Recommendation Report for Planning Permission for Works or Extension to a Dwelling

REF NO: FP/60/21/HH

LOCATION: 5 Neptune Court
Felpham
PO22 7NN

PROPOSAL: Erection of a new garden room.

PROPOSED PLANS

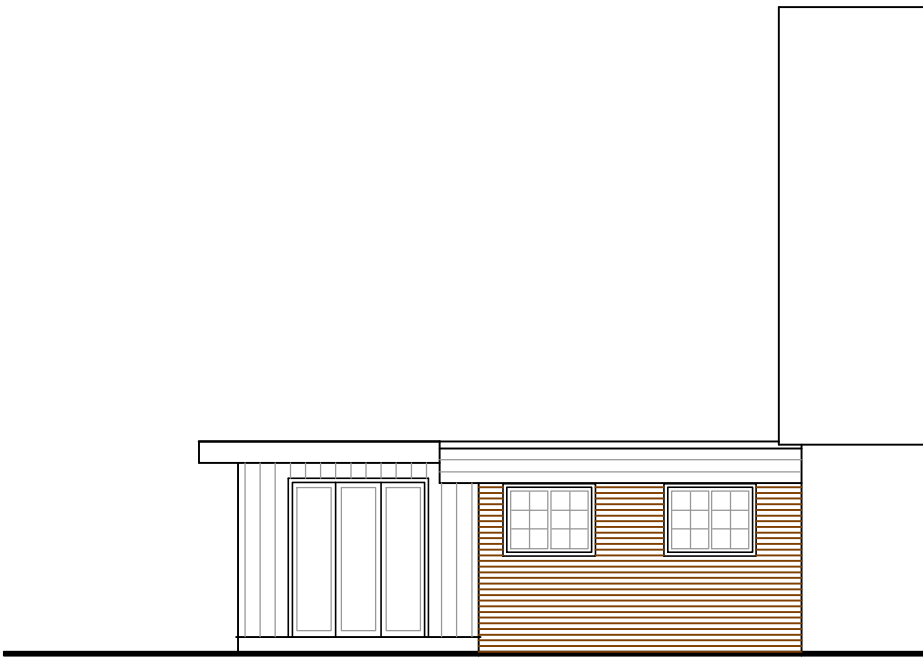
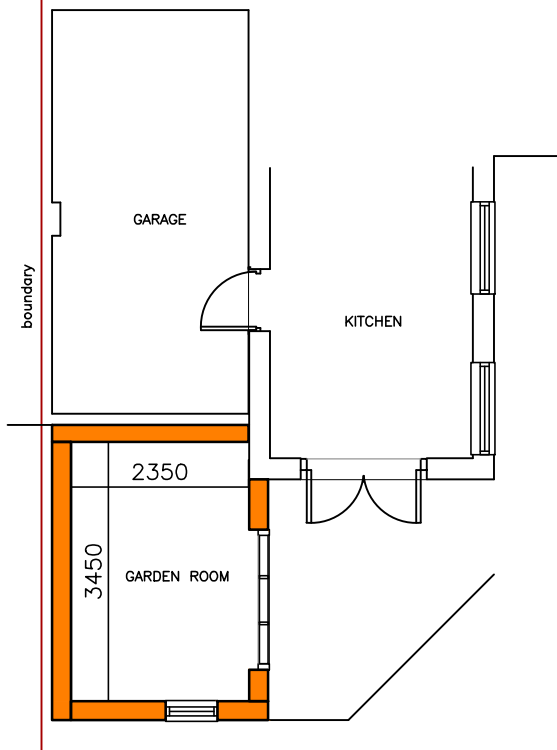
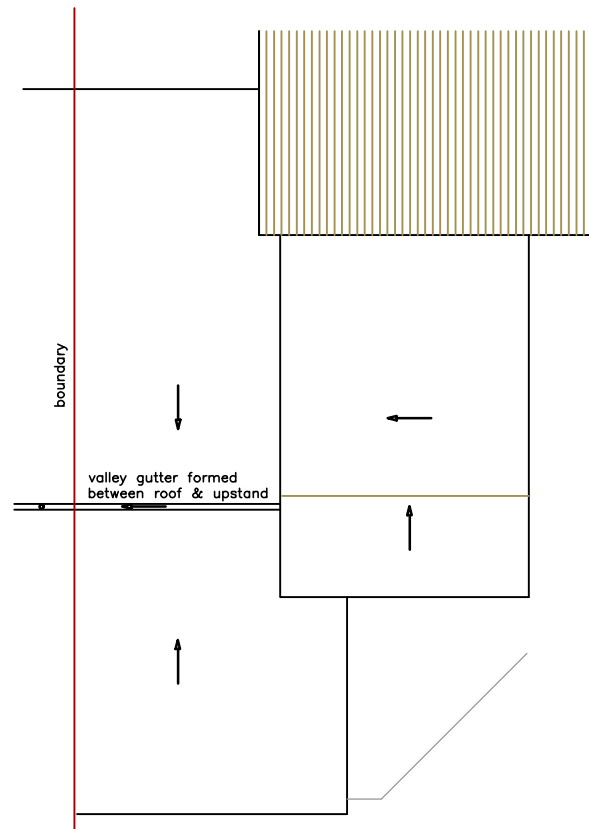
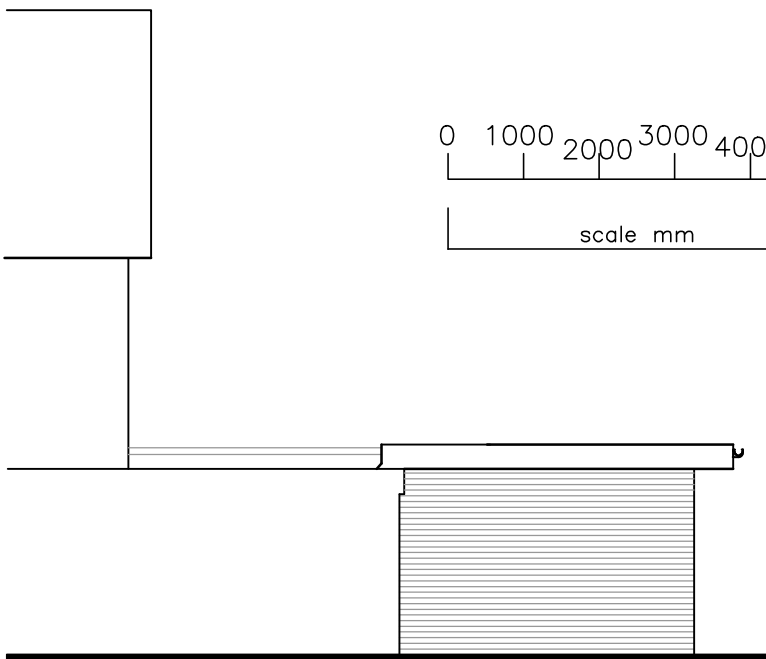
The proposal will have a width of approximately 2.87m and depth of 3.94m. The height to the flat roof will be 2.79m. There will be a single window on the north west elevation facing the rear garden and new bi-fold doors on south west elevation facing the garden to south west.

The materials integrate well with the dwelling and consist of walls of vertical weatherboarding, GRP flat roofing system and white upvc windows and doors so comply with policies D DM1 and D DM4 of the Arun Local Plan.

Whilst the proposal is within 1m of the north boundary it is at single storey with no windows in the north elevation so no harm through overlooking to neighbouring properties to north so is acceptable. Also the proposal is sited forward of the building line of neighbouring property number 6 to north east.

There is a new window on the north west elevation facing the garden to rear however due to the siting of the proposal there is a large gap remaining of 12m to rear north west boundary of property so there is no harm to overlooking to neighbours to north west.

Due to the new bi-fold doors in south west elevation of proposal, this will increase some risk of overlooking to neighbouring property number 9 to south however due to large gap remaining of 12m to south boundary there is no adverse harm to overlooking to neighbouring property to south so complies with policy D DM4 of the Arun Local Plan.
